## Bicester Bike Users Group – Response to application number 24/00245/OUT

Land Use Parameter Plan

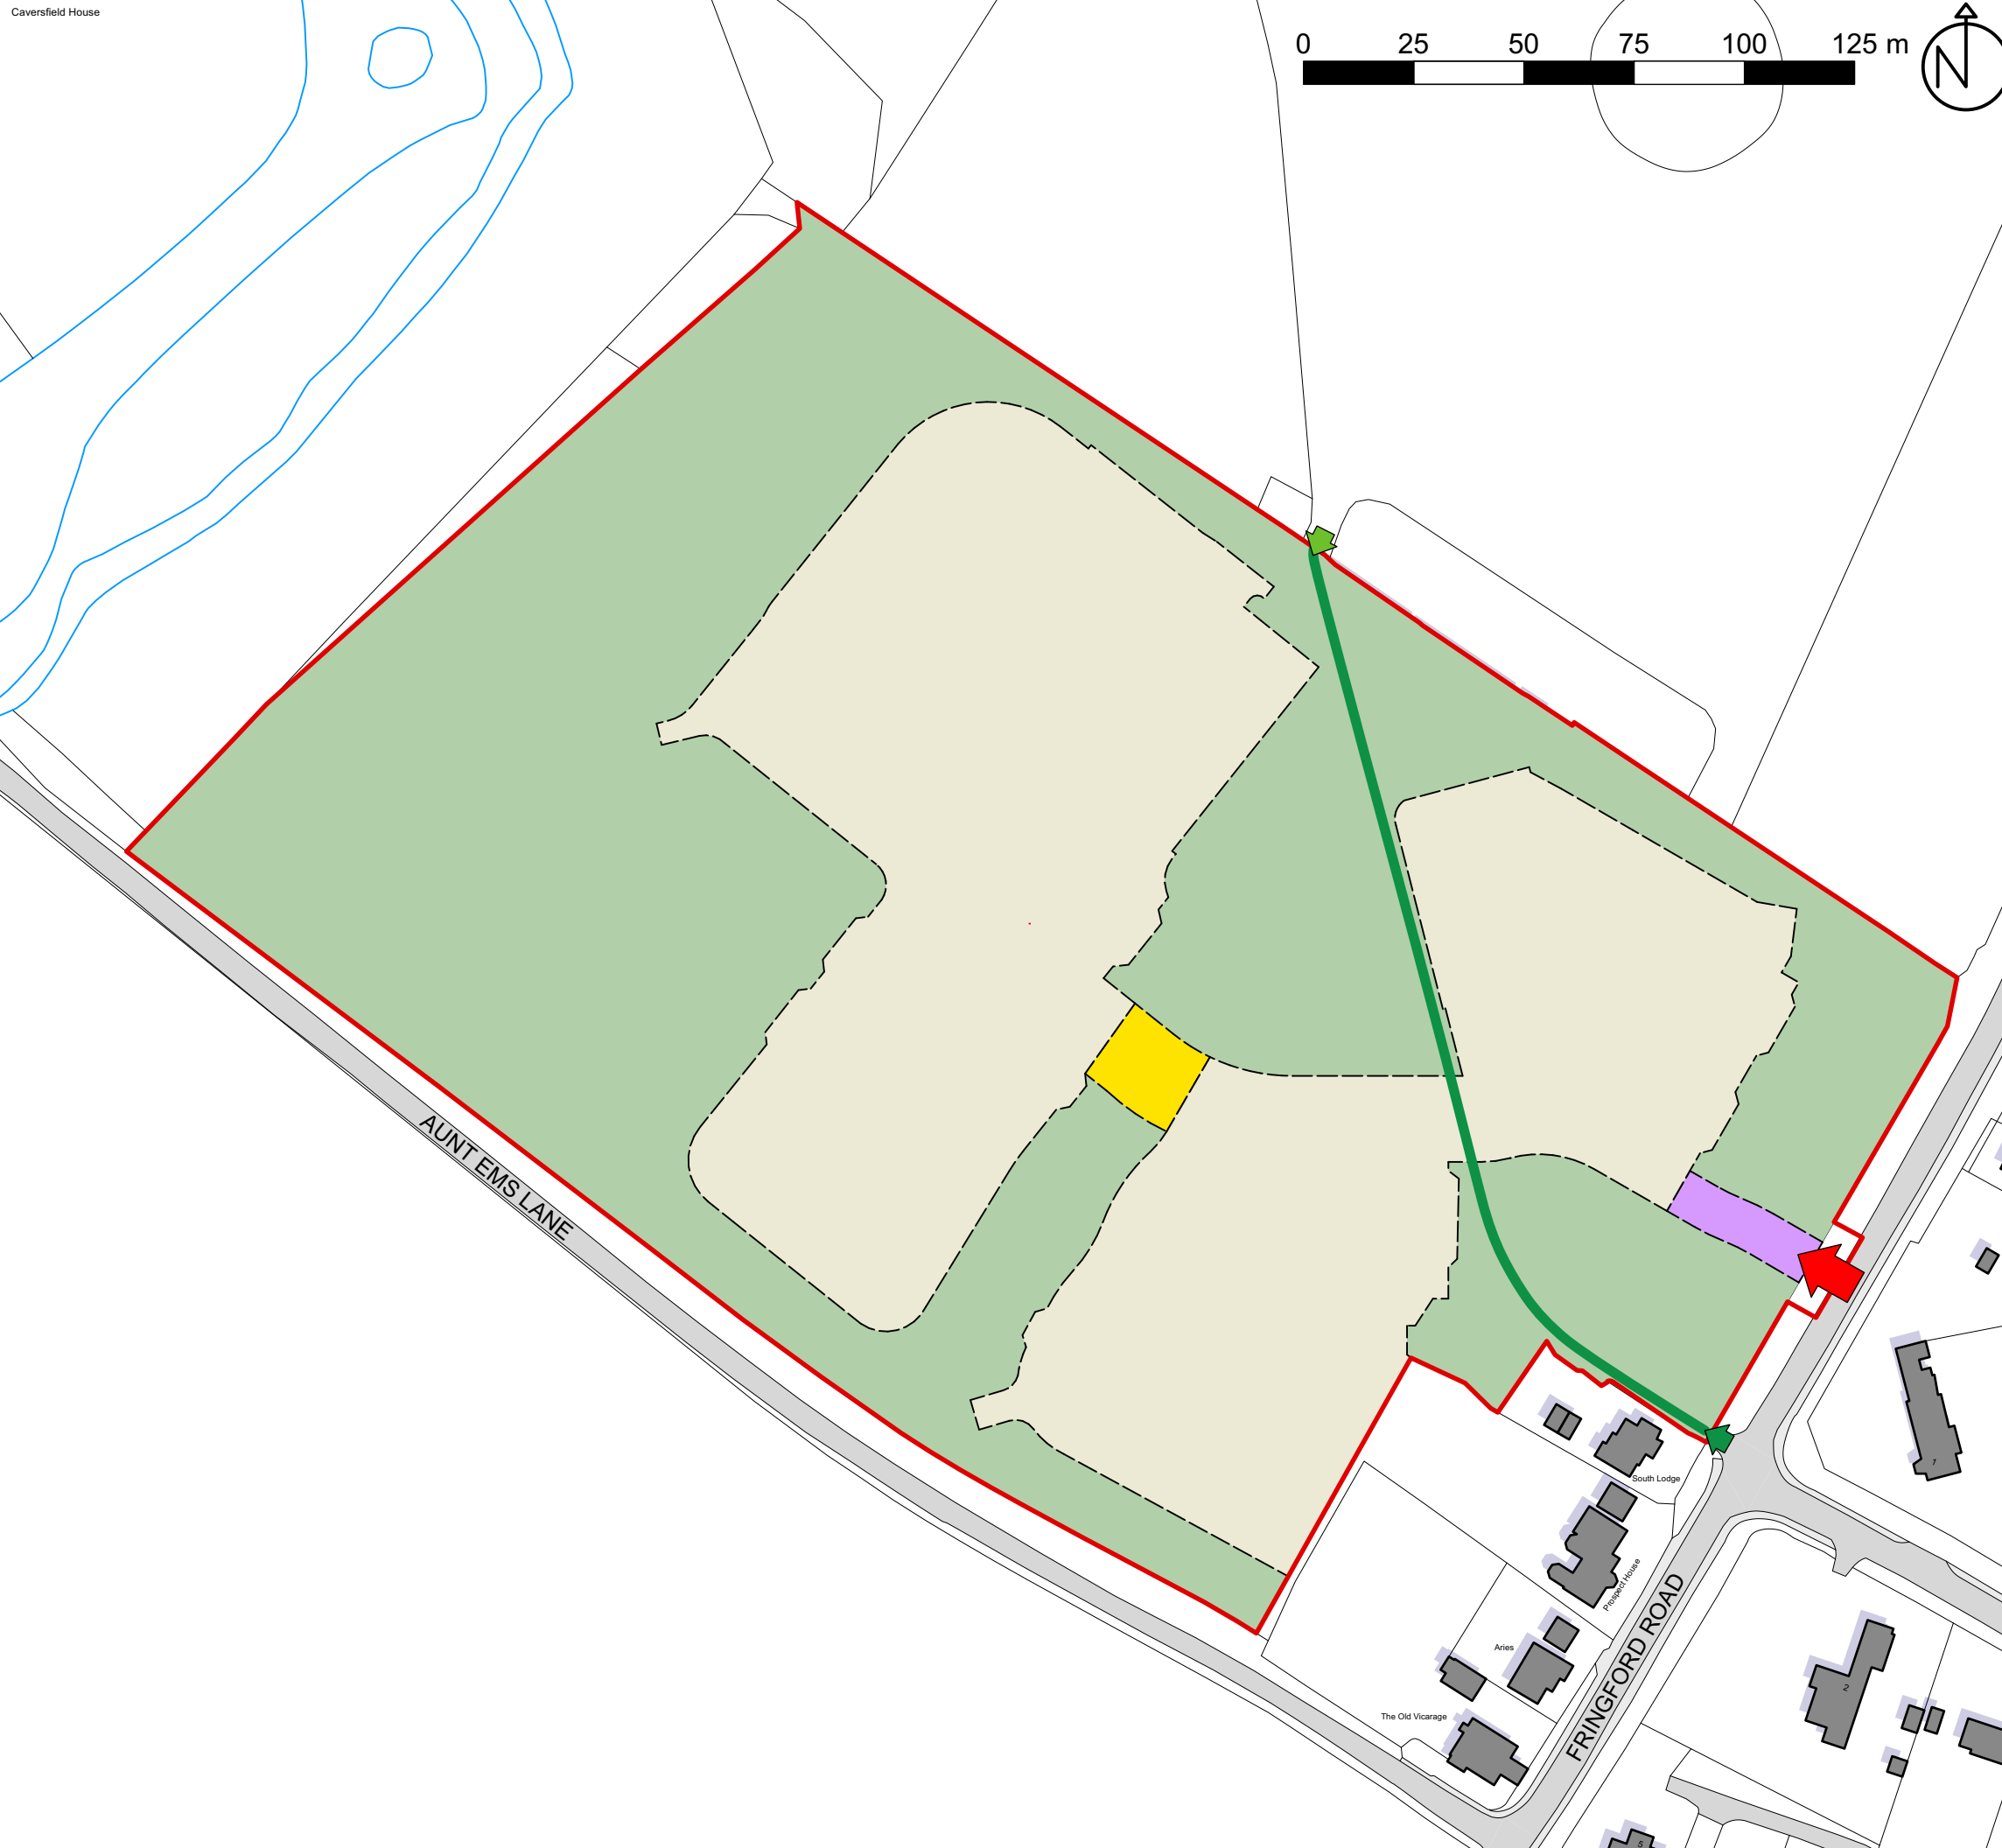
The plans for the development show a 3m shared pedestrian and cycle path into the estate. LTN 1/20 advises against shared paths and placing pedestrians and cyclists in conflict. Therefore, there needs to be a plan for segregated pedestrian and cycle ways with appropriate buffering from the highway depending on the proposed speed of the road.

In summary, at present there is not enough consideration given to active travel. The current active travel infrastructure plans are not in compliance with LTN 1/20 and OCC's own guidance. The developers need to be asked to amend the plans to allow for segregated, protected cycleways at the entrance of and within the estate, and also to provide a plan for cycles along Aunt Ems lane and at the crossing at Banbury Rd to allow access to NW Bicester.
